Our ref: L.A11230.003.StPhilipsCC-RTS.docx

25 October 2022

RE: RESPONSE TO SUBMISSION - ST PHILIP'S CHRISTIAN COLLEGE, CESSNOCK SSDA

Table 1.1 Response to Submission

PMF Pre-development Peak Flood Level

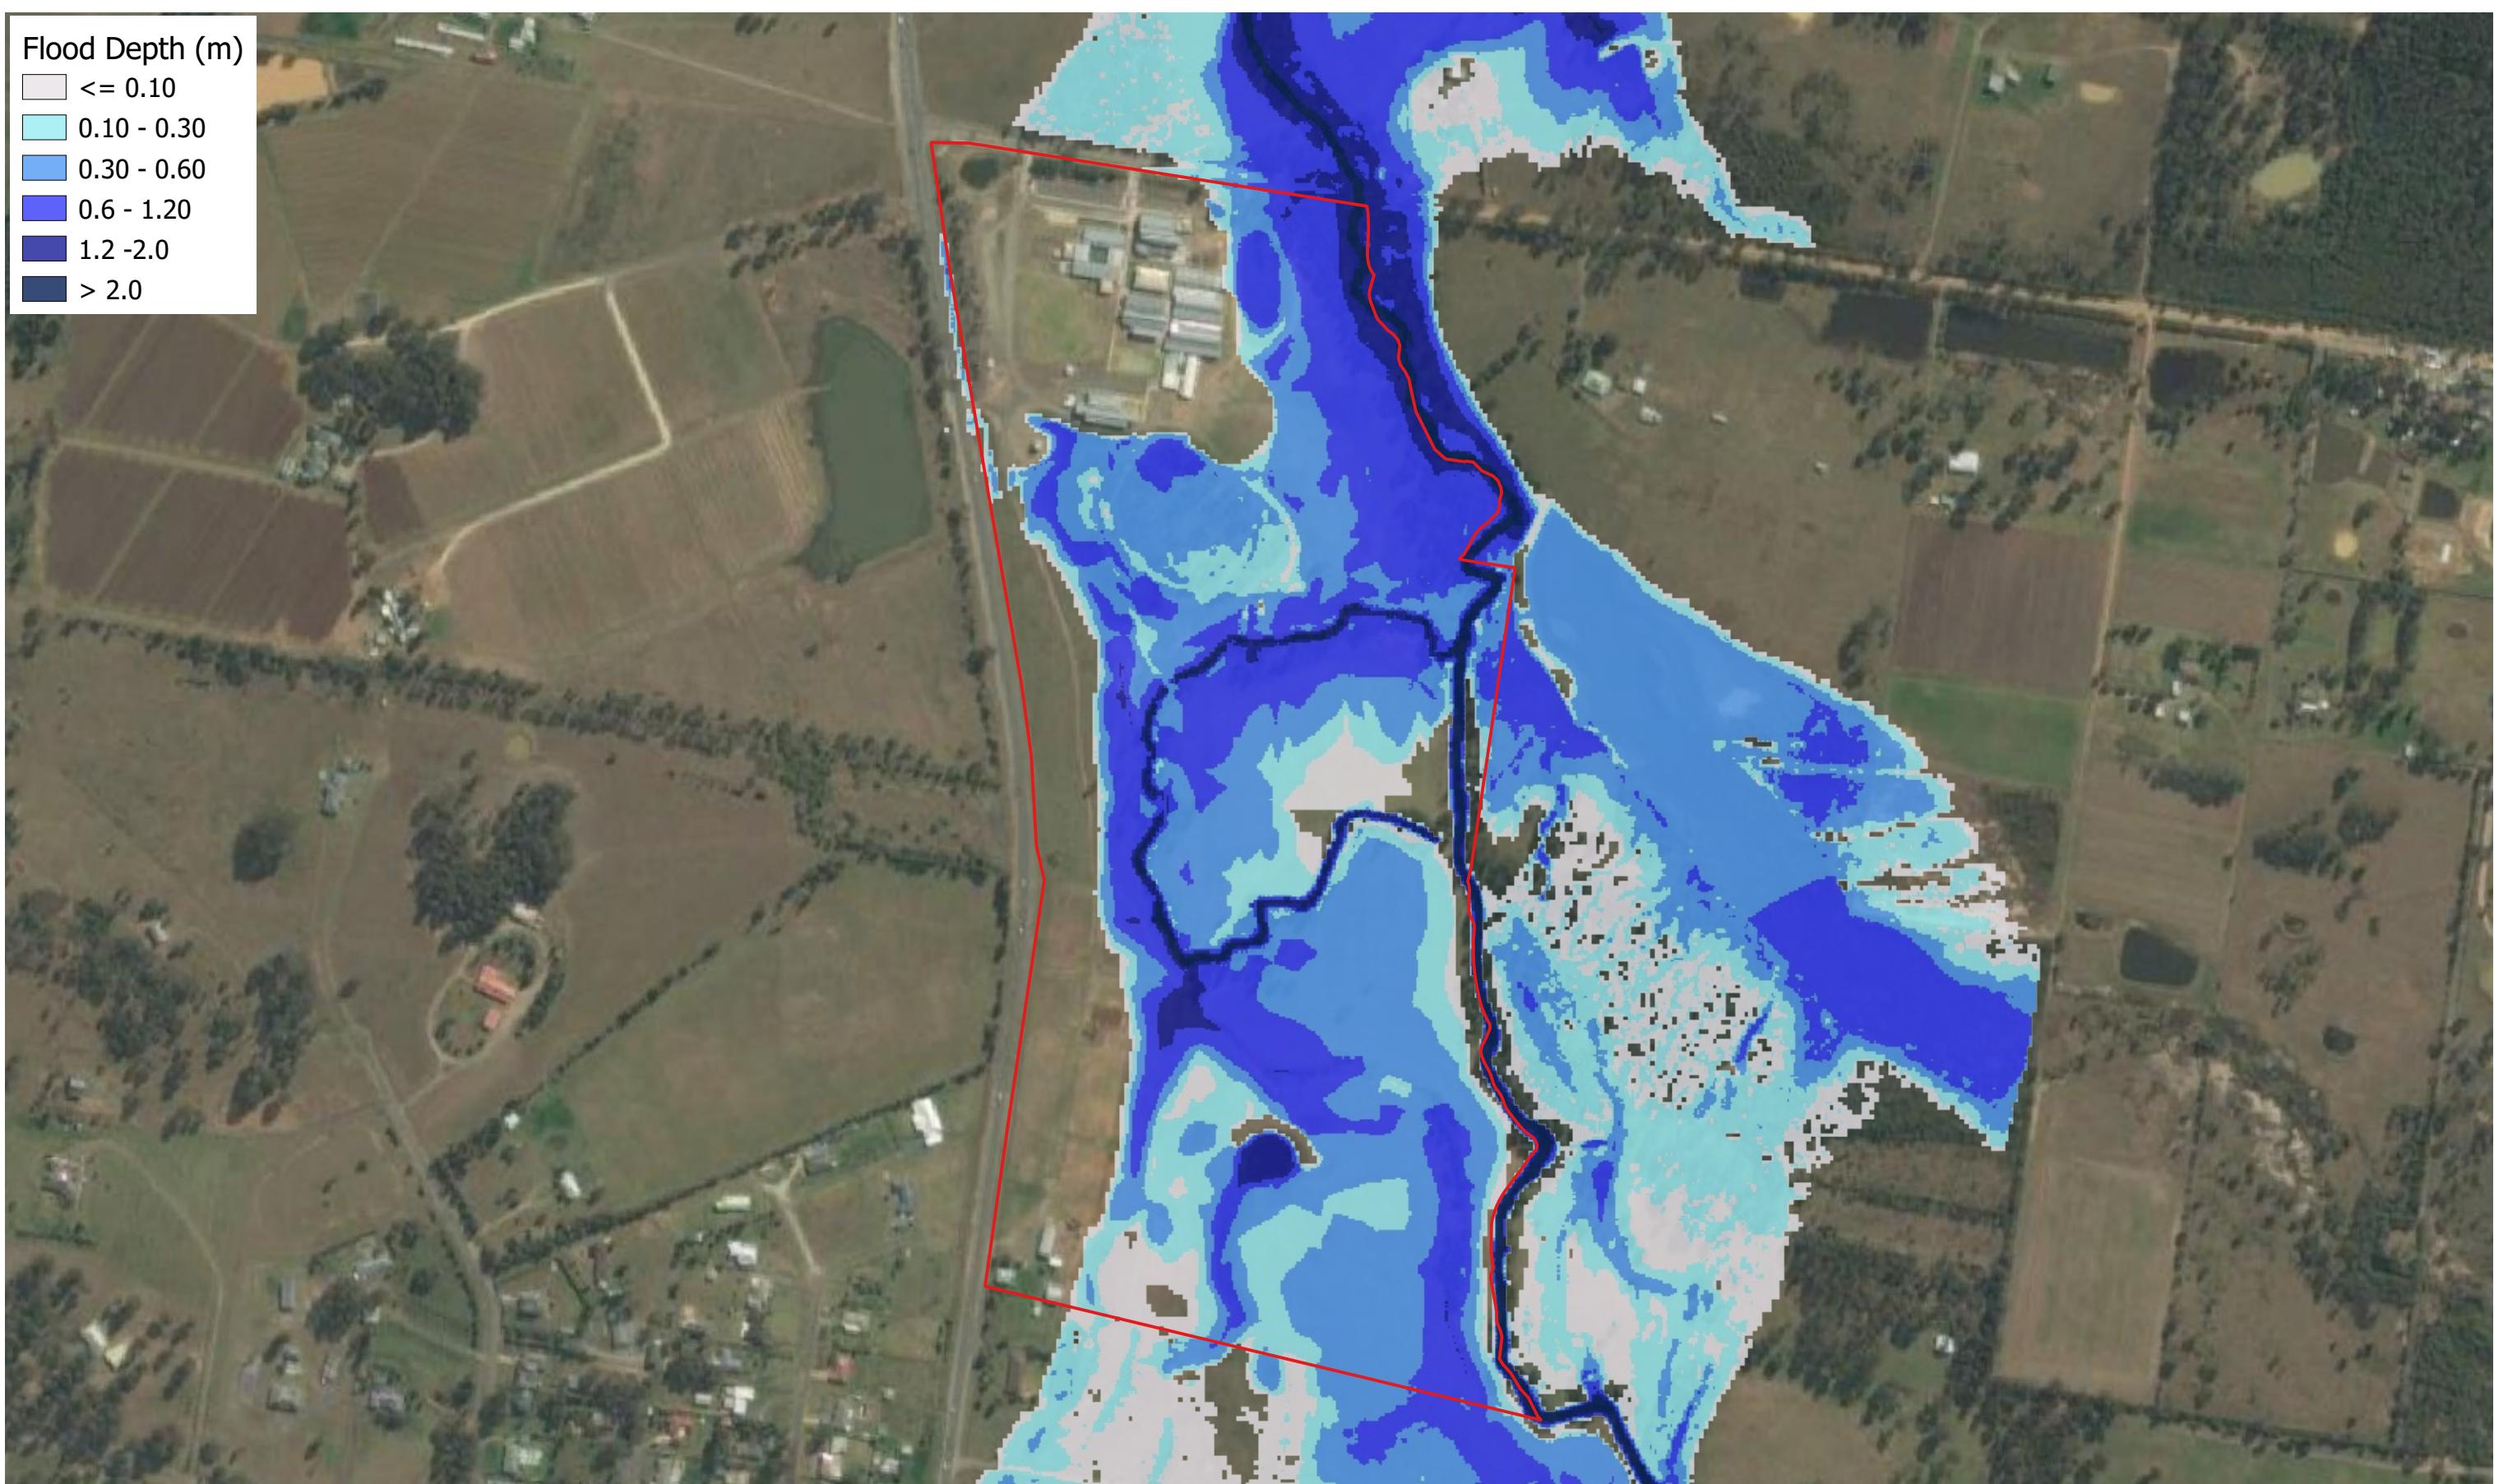
• <i>Distribution of flood water is shown to increase between 20-50mm along the eastern boundary to Lot 892 DP 574957.</i>	Whilst offsite flood impact due to the proposed development is predicted to occur for the 2% AEP event and above, the peak flood level increase beyond the acceptable 20mm threshold is marginal (which occurs in area subject to typical peak flood depth in excess of 1m) and the impacted extent is confined within the Black Creek corridor (negligible change in encroachment). Neither the existing residential building within the neighbouring lot (Lot 892 DP 574957) is affected nor the flood hazard of the impacted area is significantly altered (hence minimal change to existing flood risk).
<u>Department of Planning and Environment</u>
